Ribble Valley Borough Council  
By email

Your ref 3/2024/0092  
Our ref DC/24/497  
Date 13-MAR-24

**Location: Plane Tree Farm Chipping Road Chaigley BB7 3LT.**  
**Proposal: Prior notification for general purpose open-sided agricultural building 18.28m long, 9.14m wide 4.27m high to eaves, 5.57m high to ridge**

Dwg No.: OT169-4

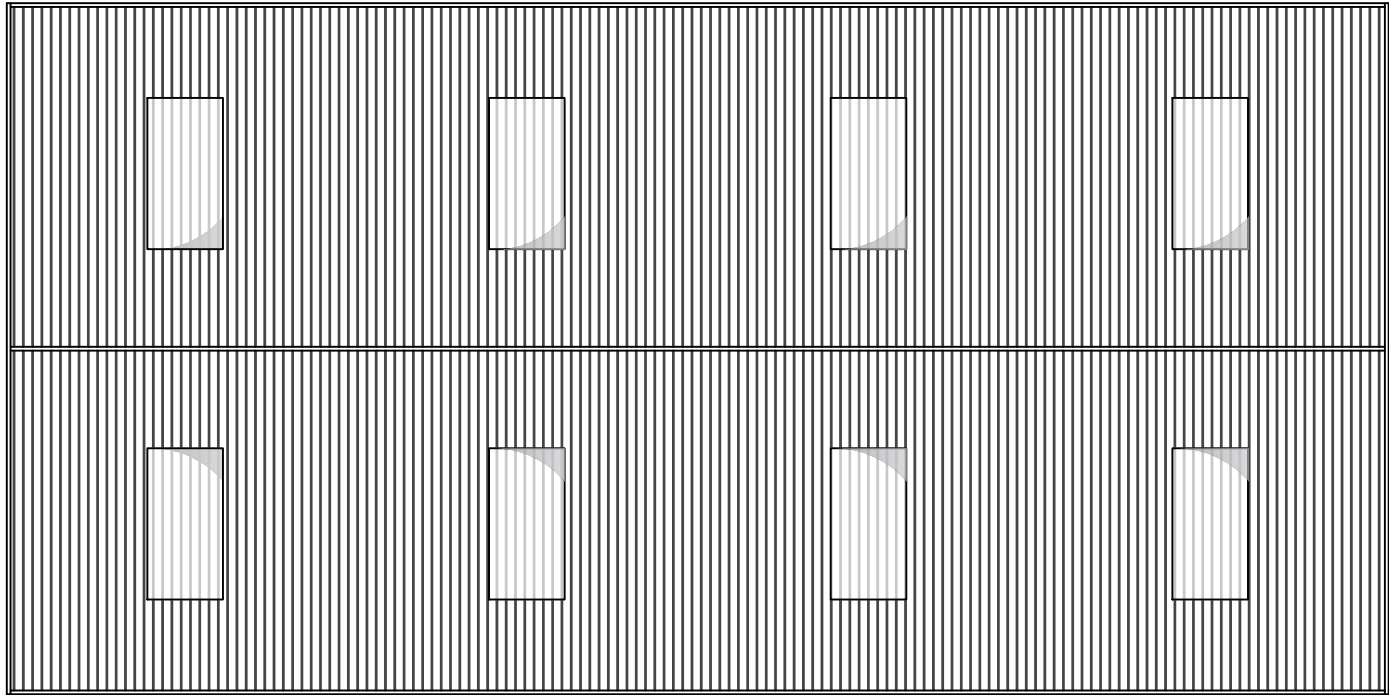
Following our review of the proposed site layout, we can confirm that the proposal is not acceptable to United Utilities as proposed features appear to be located in close proximity to our trunk main. Until such time as the applicant has resolved all concerns regarding the proximity of proposed development to our water assets, our position is that we **OBJECT** to the proposal.

From the information currently available, it is unclear if the applicant's proposals might compromise United Utilities' easement. Without clarity on this proximity of proposed features relative to the easement, there is a risk that in addition to our current objection relating to the water main, the proposed plans may not be implementable in their existing form due to this private property matter. It is the applicant's responsibility to investigate this matter and we strongly recommend this matter is resolved PRIOR TO DETERMINATION.

To overcome our objection, we will require a detailed site layout plan which overlays the **PROVEN** location of the water main and associated easement, in relation to any proposed development, including walls, fencing, parking etc. Please note, a copy of asset maps will not suffice.
